Case Officer: Andrew Thompson

Applicant: Begbroke Oxford Limited

Proposal: Amended wording of condition 17 to allow very minor changes to the approved permissive pedestrian and cycle route (proposed as non-material amendment to 18/00803/OUT)

drawing number: LP2264-FIR-00-ZZ-DR-L-0010

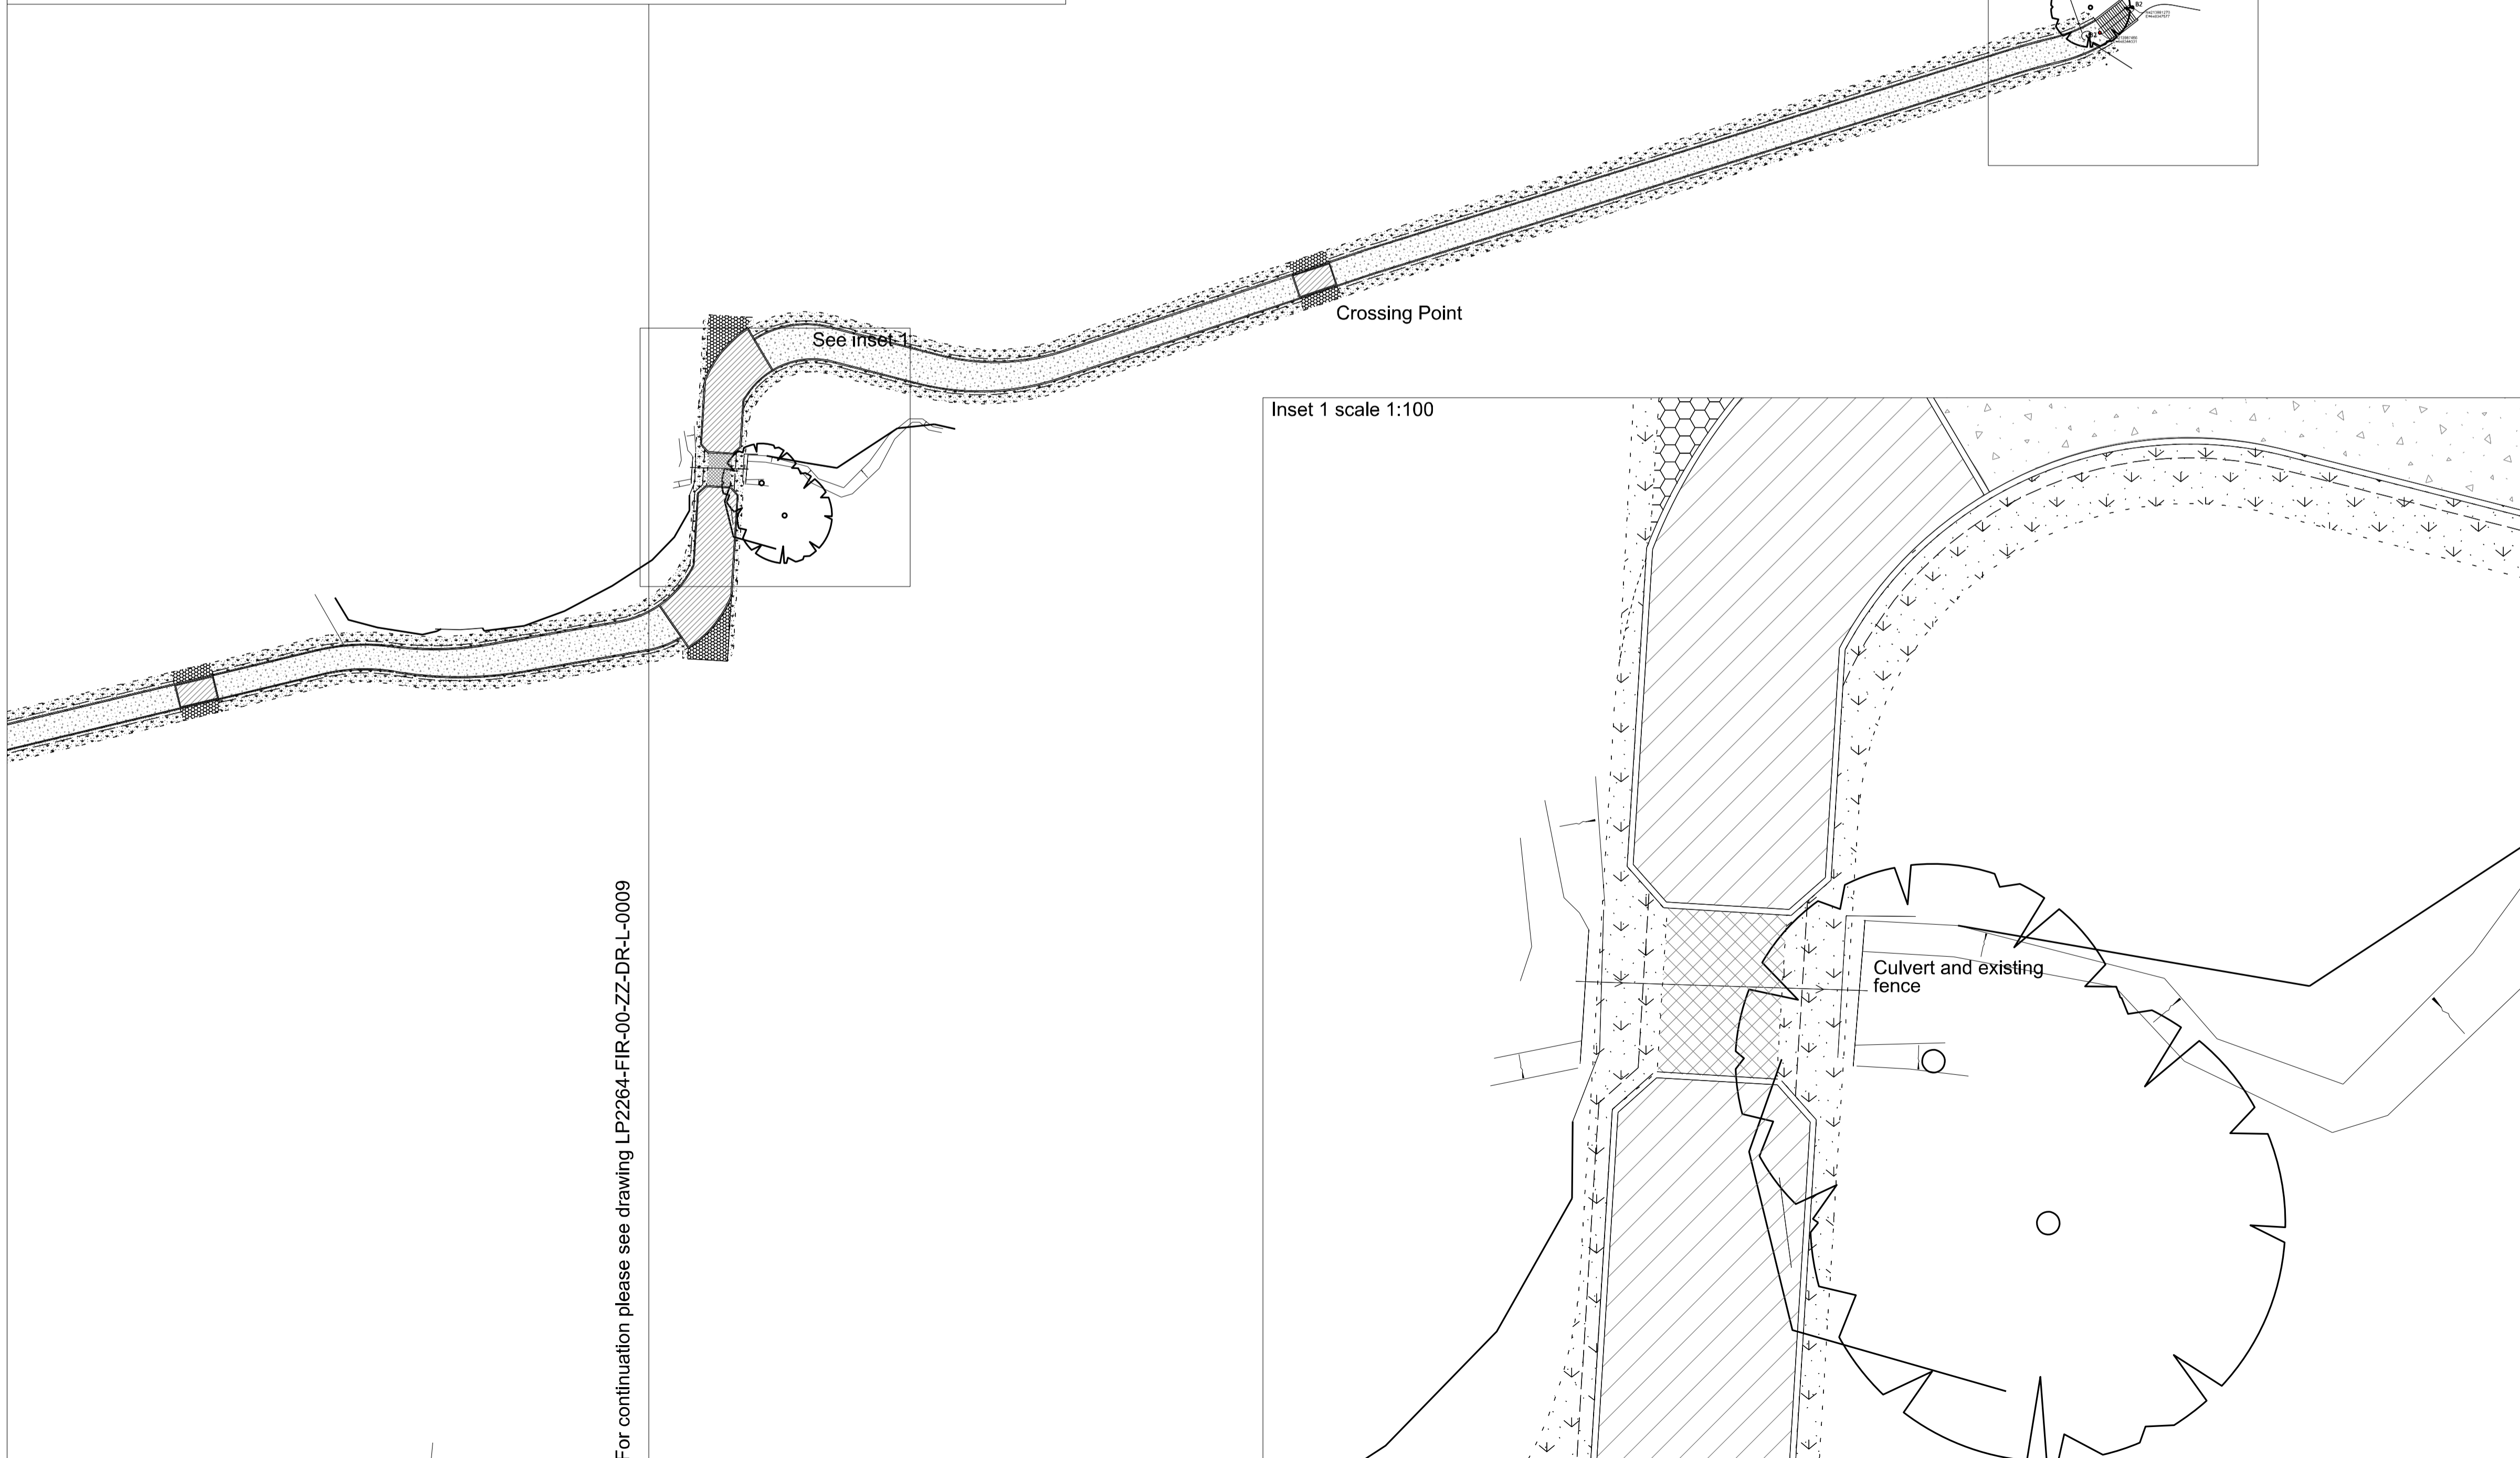
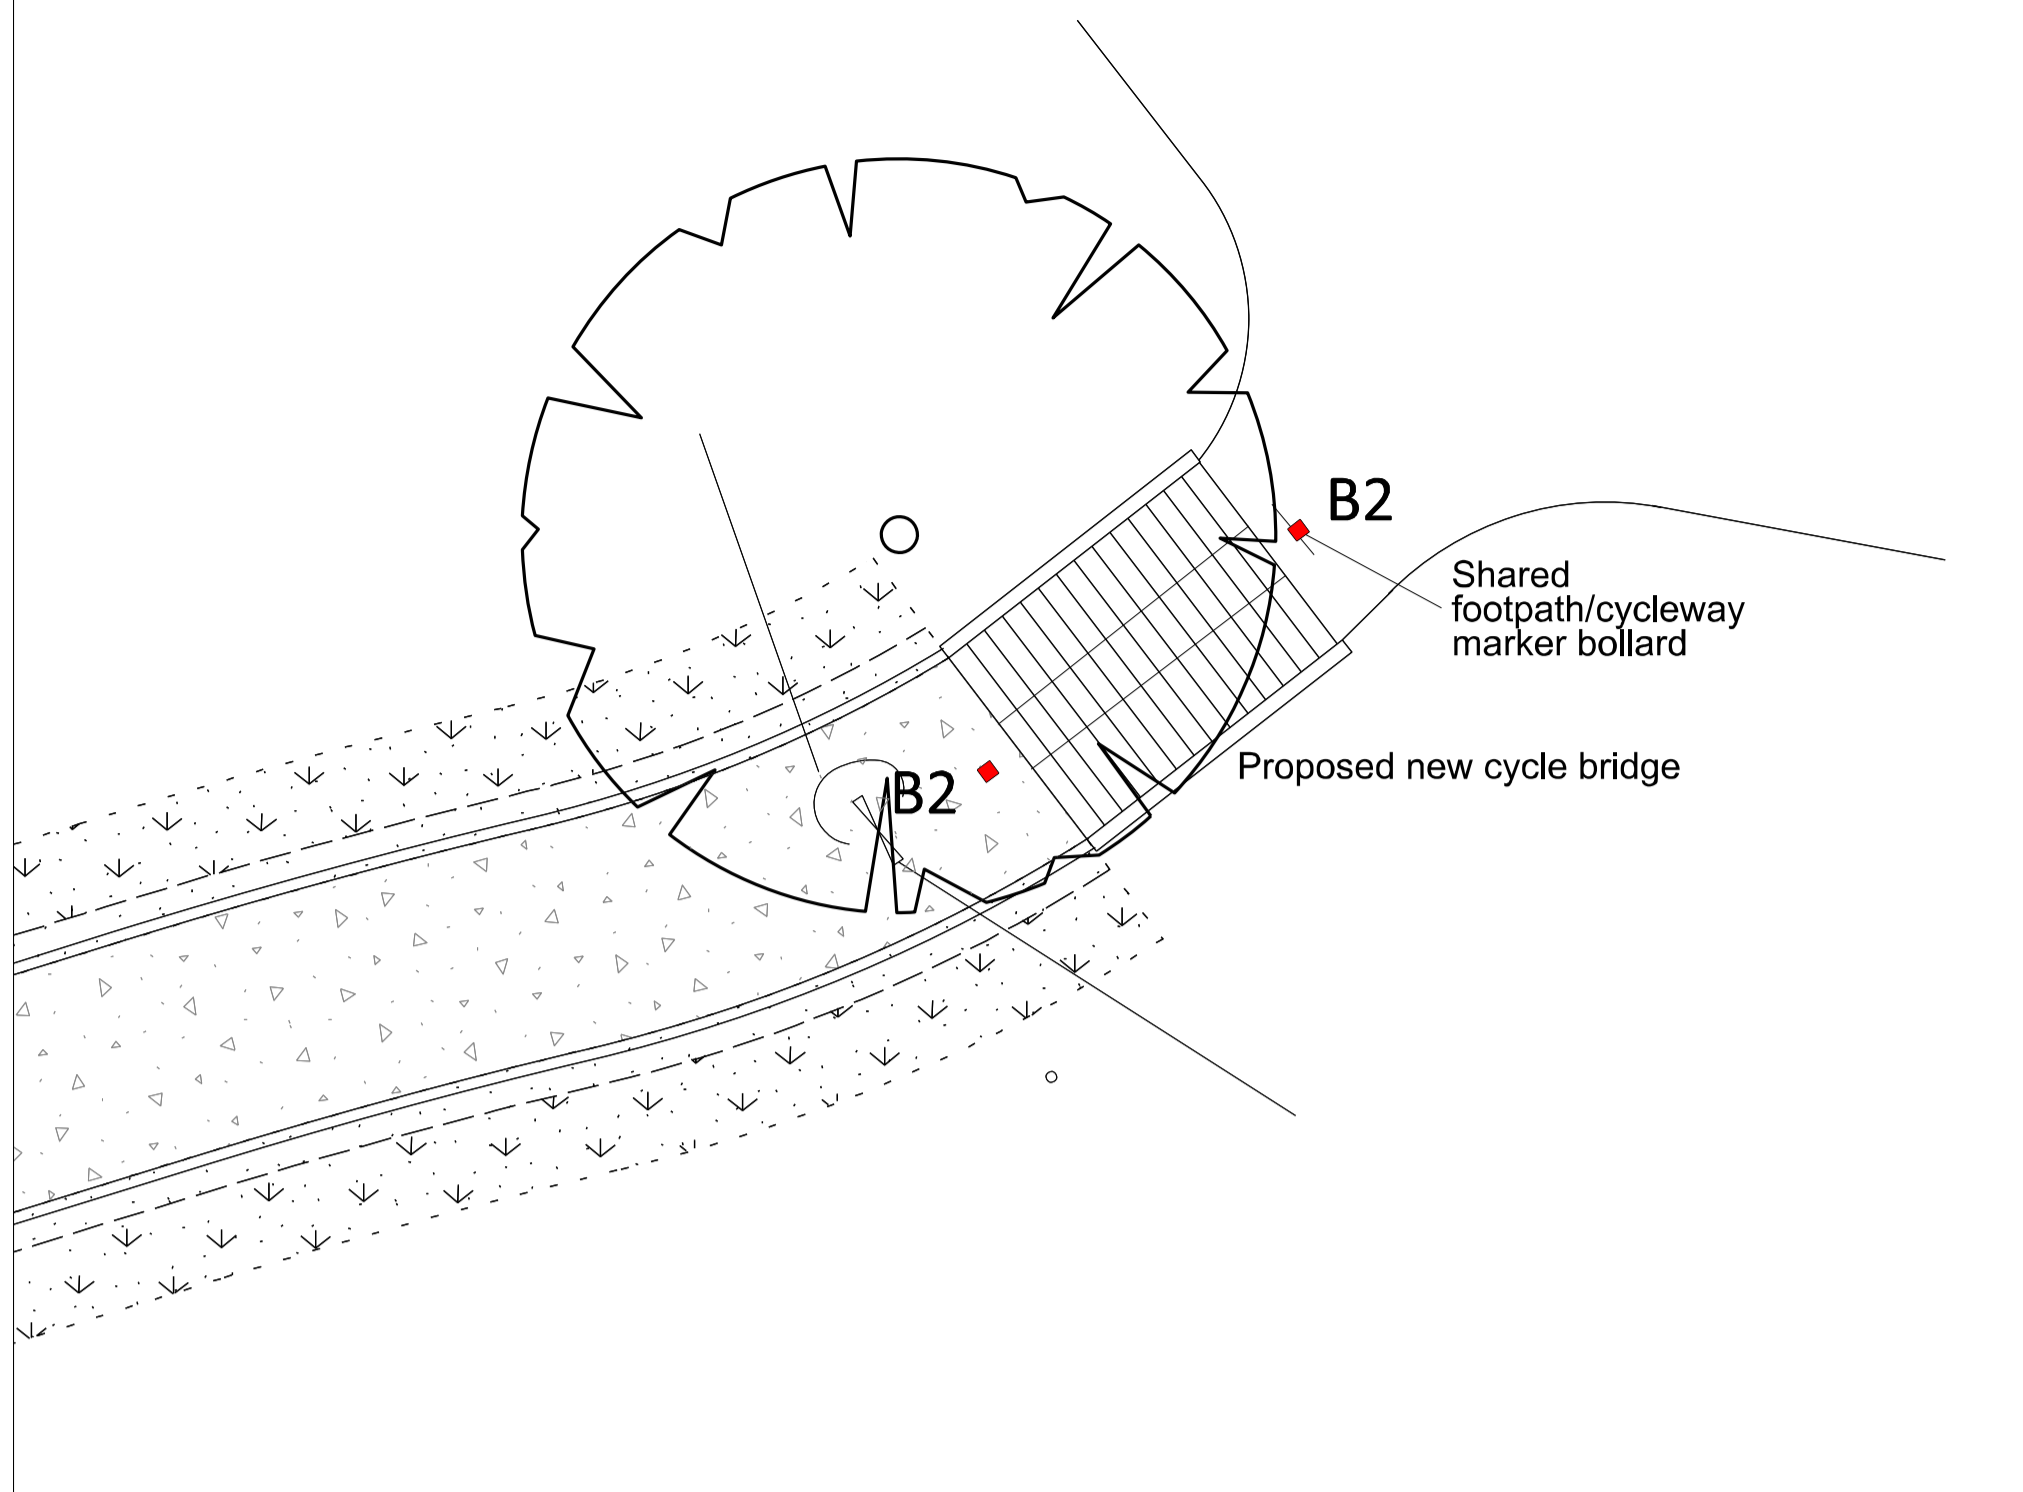
The proposed post and rail fence from the permissive pedestrian and cycle route is proposed to be removed. This NMA application seeks to vary the wording of the above condition to allow work to be carried out in accordance with the details agreed on site.

2.3. The revised drawings remove the fence on either side of the permissive cycle path and footpath other than over the bridge but include two new bollards, one on the internal side of the bridge and another by Begbroke Campus, to deter vehicle access.

The revised drawings remove the fence on either side of the permissive cycle path and footpath other than over the bridge but include two new bollards, one on the internal side of the bridge and another by Begbroke Campus, to deter vehicle access. These changes remove unnecessary pieces of infrastructure which would need to be removed as part of the wider redevelopment under PR8 and is not required as part of the wider allocation and would not compromise the current footpath objectives.

A permissive pedestrian and cycle route between Begbroke Science Park and the restricted byway at Roundham Bridge that is suitable for use year-round, shall be provided in accordance with the following plans:

- LP2264-FIR-00-ZZ-DR-L-0010 P02
